WELWYN HATFIELD BOROUGH COUNCIL – DEVELOPMENT MANAGEMENT
DELEGATED REPORT

APPLICATION No:	N6/2012/2455/FP
APPLICATION Site:	24 Rooks Hill

The application seeks full planning permission for the erection of a two storey side and single storey rear extension.

Project:	24 ROOKSHILL, WELWYN GARDEN CITY, HERTS.		
Drawing Title:	PLANS & ELEVATIONS AS PROPOSED		
Drawn By:	DAMIEN	Scale: 1:100	Date: nov 2012
Design Stage:	PLANNING	Checked:	
Drawing No:	2932-P01 Rev A		Revision:

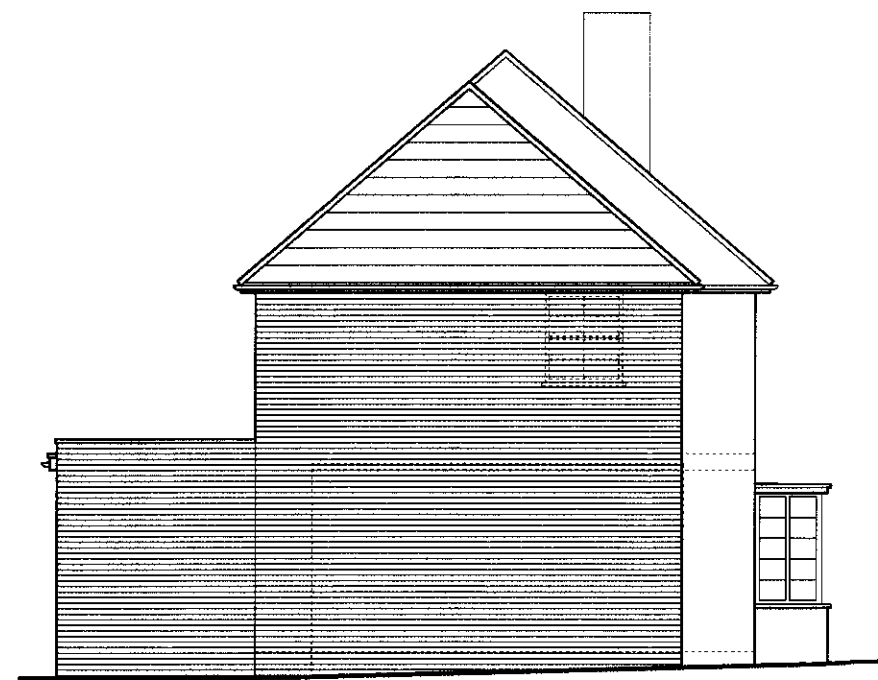
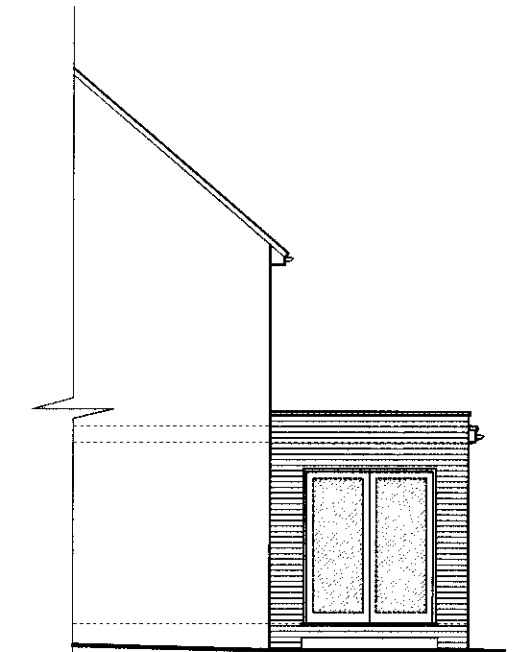
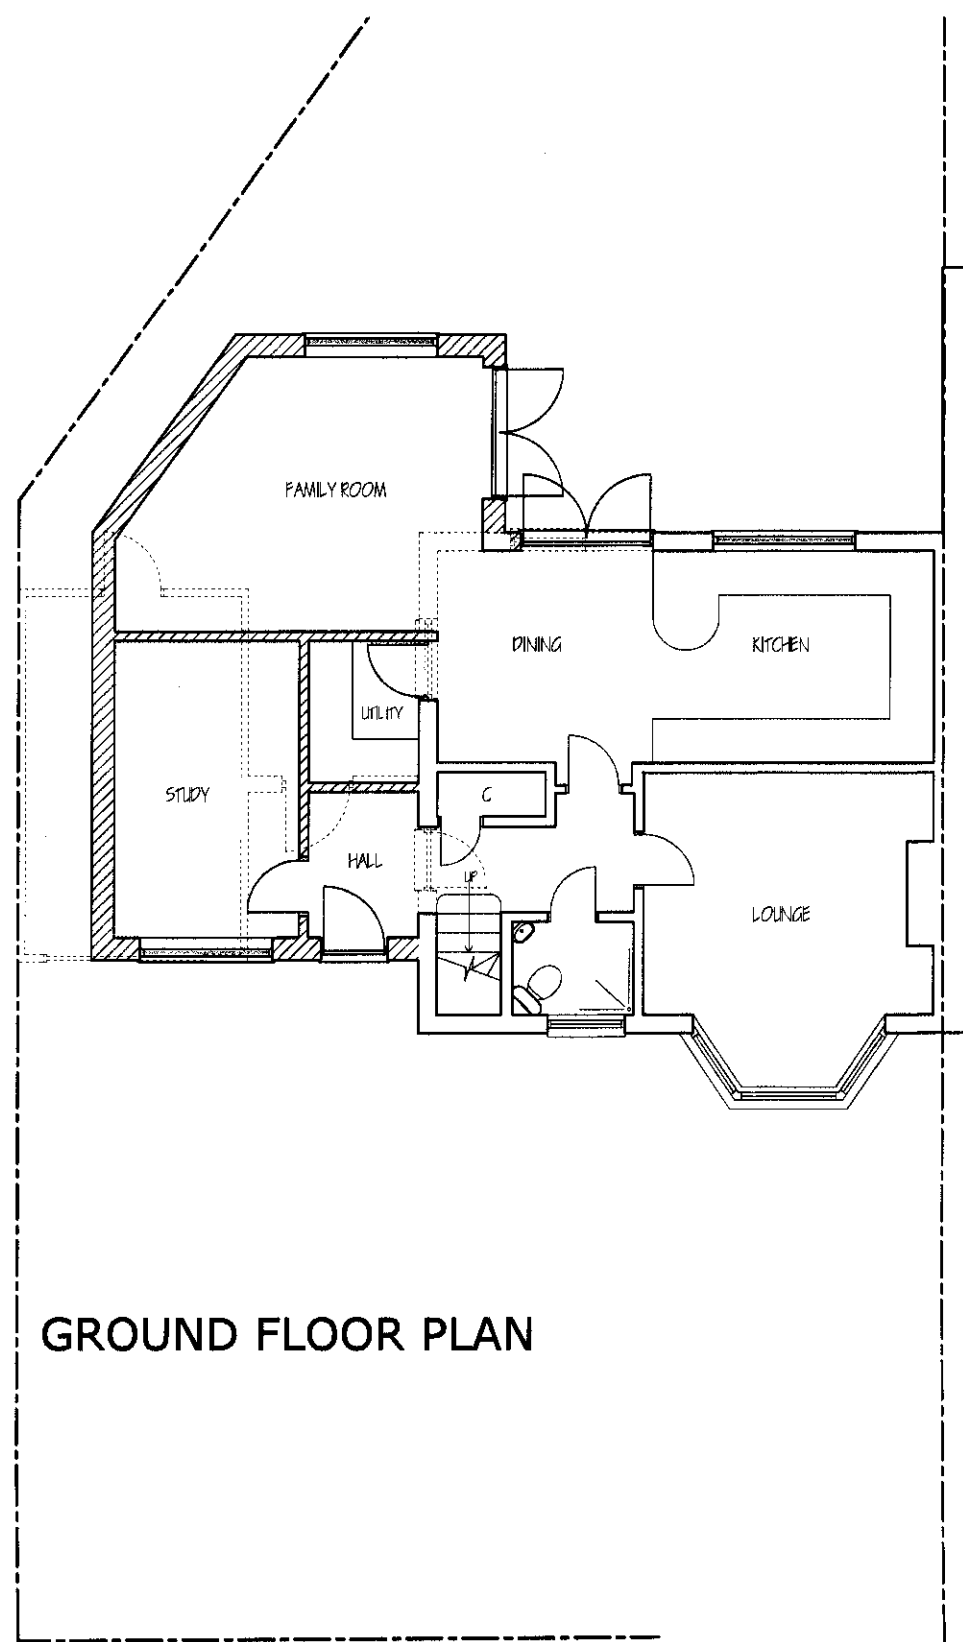
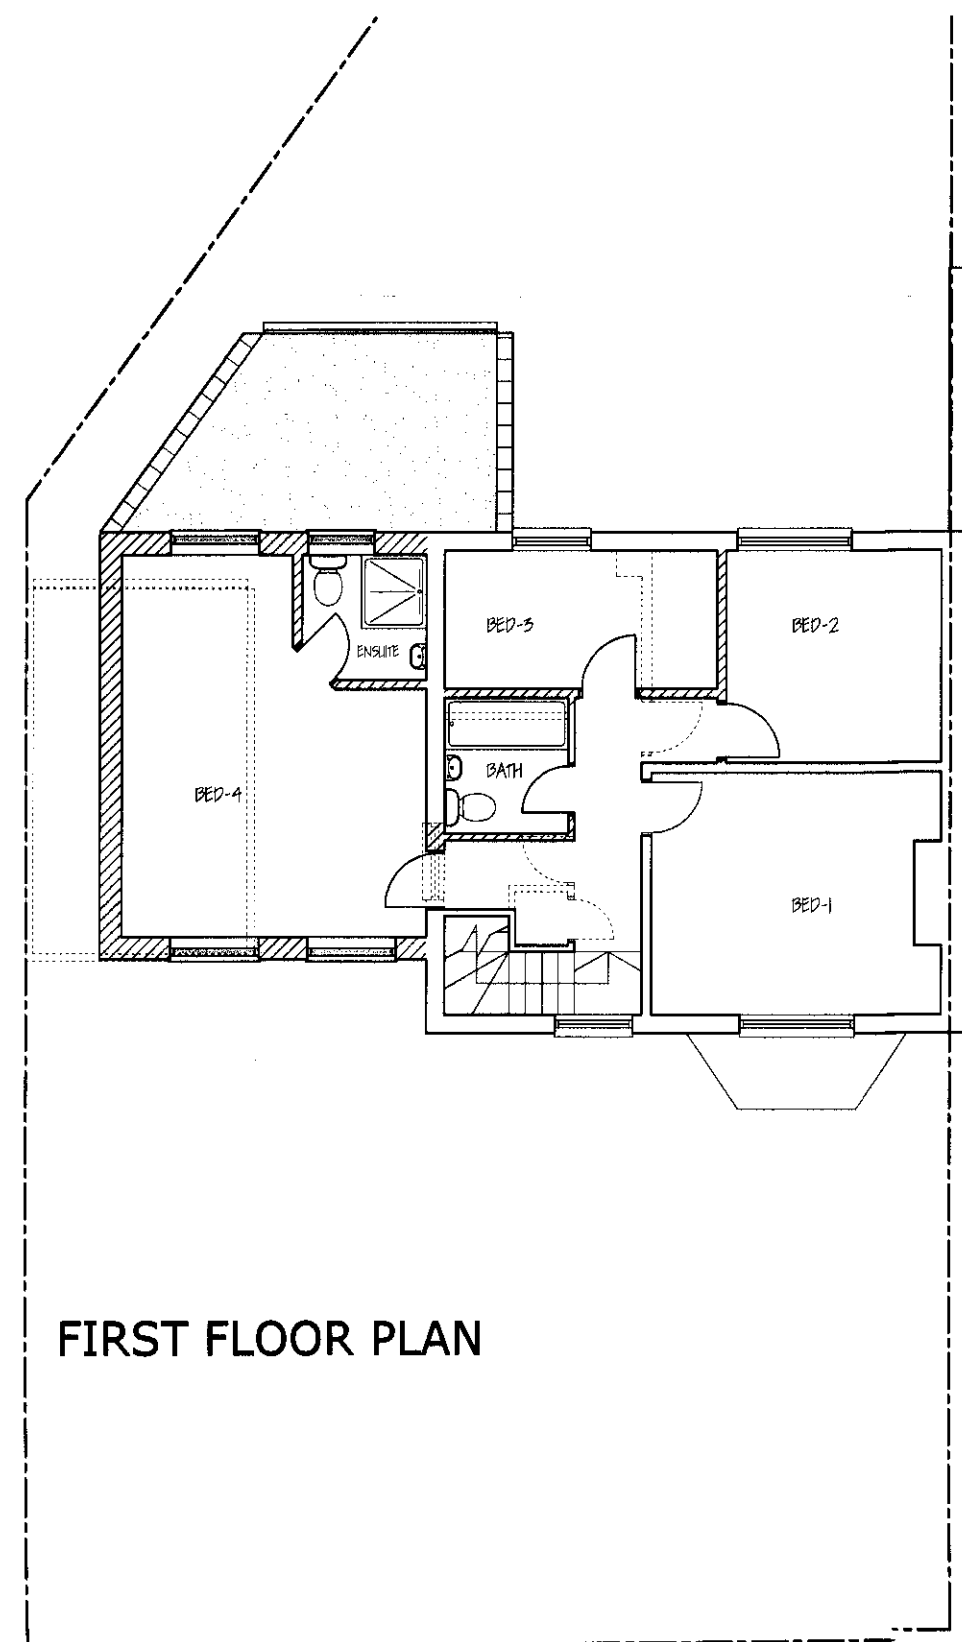
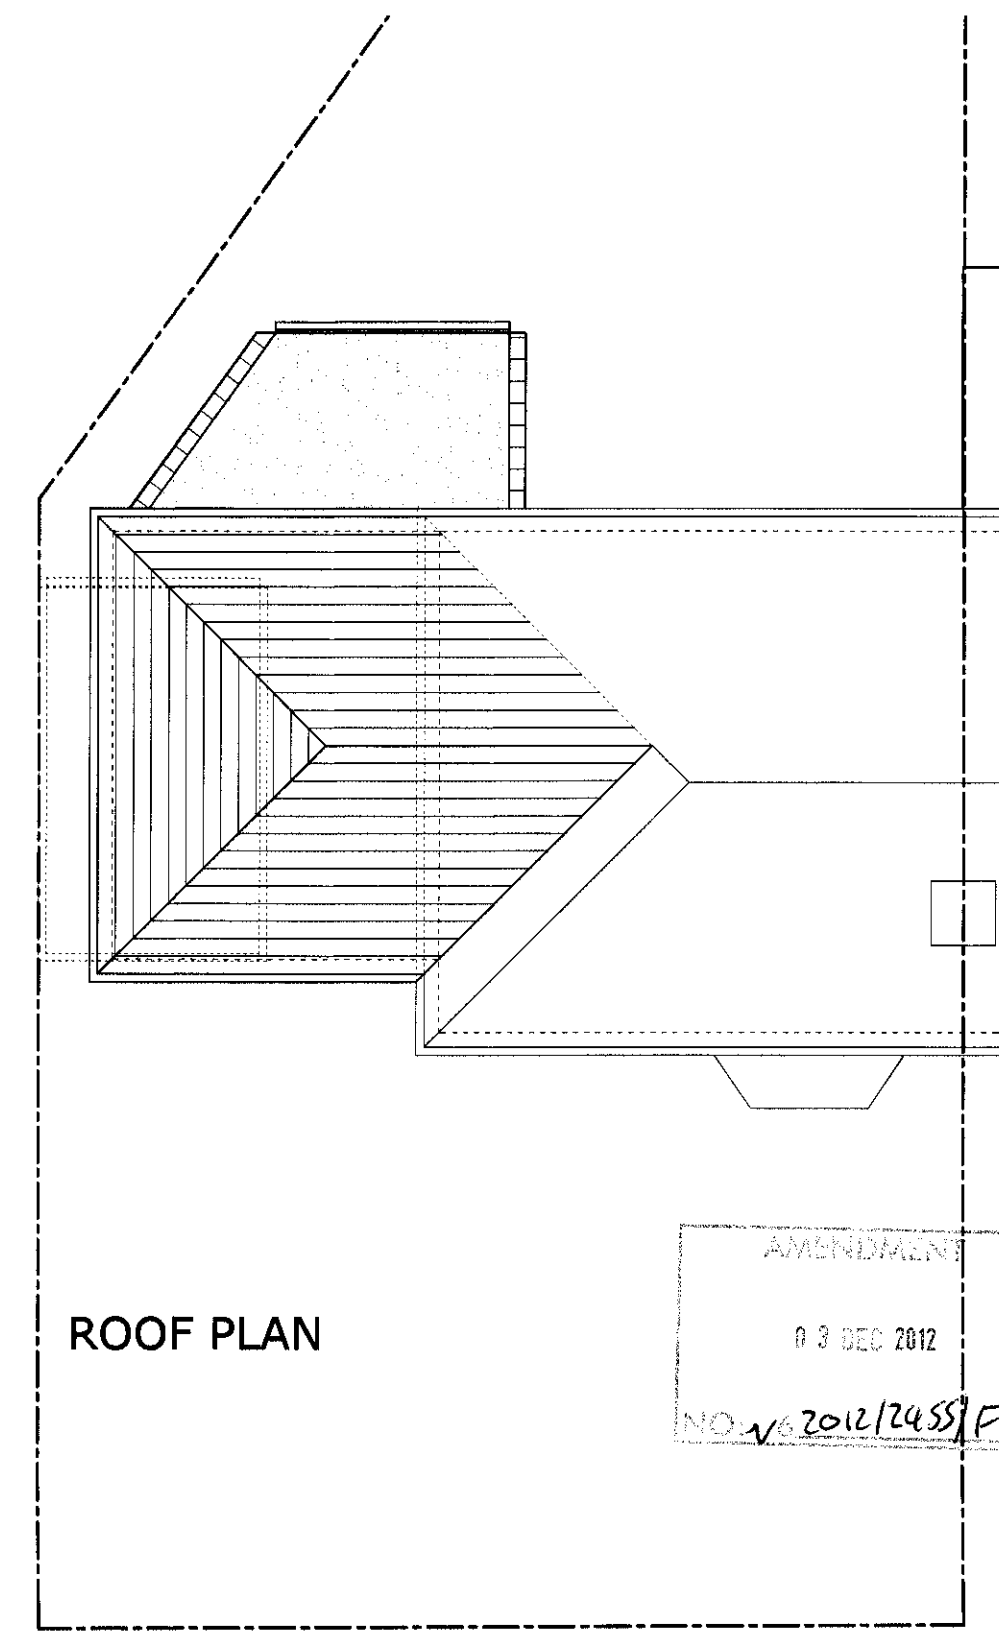
The side extension would be approximately 4.3m in width, 7.9m in height and 5.1m in depth. It would feature a hipped roof with a ridge reduced by approximately 0.4m against the height of the existing dwelling. The extension would be set back from the main wall of the principal elevation by approximately 0.9m.

The rear extension would be approximately 5.5m in depth shortening to 3.6m, 2.7m in depth and 3.1m in height. It would be located mainly to rear of the proposed side extension, with an overlap of approximately 1.1m into the width of the rear of the existing dwelling. It would feature a flat roof with parapet wall and would run parallel to the boundary line, distanced by approximately 1.0m.

The proposal would include a considerable increase in footprint, which would equate to over 60% against the existing dwelling. However, the proposals have incorporated some measures to limit the visual impact, with the side extension featuring a reduction in ridge height at first floor level and a set back from the principal elevation. Furthermore, the rear extension would be of a modest scale and would feature a flat roof. Therefore despite the large increase in overall floor space, it is considered that the proposed development would appear subordinate to the existing dwelling and would not excessively alter the character of the dwelling itself.

Despite this, it is considered that this development would result in a visual imbalance within the street scene. There are few examples of side extensions in the area at first floor level and the result of this is the preservation of the area's original character. Development to the side only exists currently at single storey level, in the form of a garage. Whilst the rear extension would be appropriate, the two storey side extension would appear inconsistent with the character of surrounding development. Its prominence would be particularly noticeable when approaching the property from the west, and the proposed set back would not be sufficient given the scale of the extension. It is therefore considered that this two storey development would have excessive visual prominence, appearing incongruous within the wider street scene.

With regards to the more detailed aspects of design, the proposal includes matching brickwork and roof tiling. However, the fenestration design would be inconsistent with the existing dwelling both at the front and rear of the dwelling. It is considered that this would not justify refusal however, as a condition could be applied to ensure an appropriate match.

The proposal would bring the flank wall closer to the boundary. This would result in a minor impact on overshadowing and impact on outlook on 26-30 Rooks Hill. However, it is considered that the impact would not be overly excessive to warrant refusal. There would be no windows on the side elevation of the side extension, thereby restricting any overlooking impacts. There would be some windows at first floor level on the rear elevation. These would overlook onto the rear gardens of 34

1. The proposed development by virtue of its location, size, form and design, would be out of scale and would fail to respect the character of the wider area. The two storey side extension would appear inconsistent with the nature of development within the area and would therefore appear as an incongruous addition that would fail to sustain or enhance the significance of the Welwyn Garden City Conservation Area. The proposal would therefore be contrary to the design requirements of policies D1 and D2 of the Welwyn Hatfield District Plan and the National Planning Policy Framework.
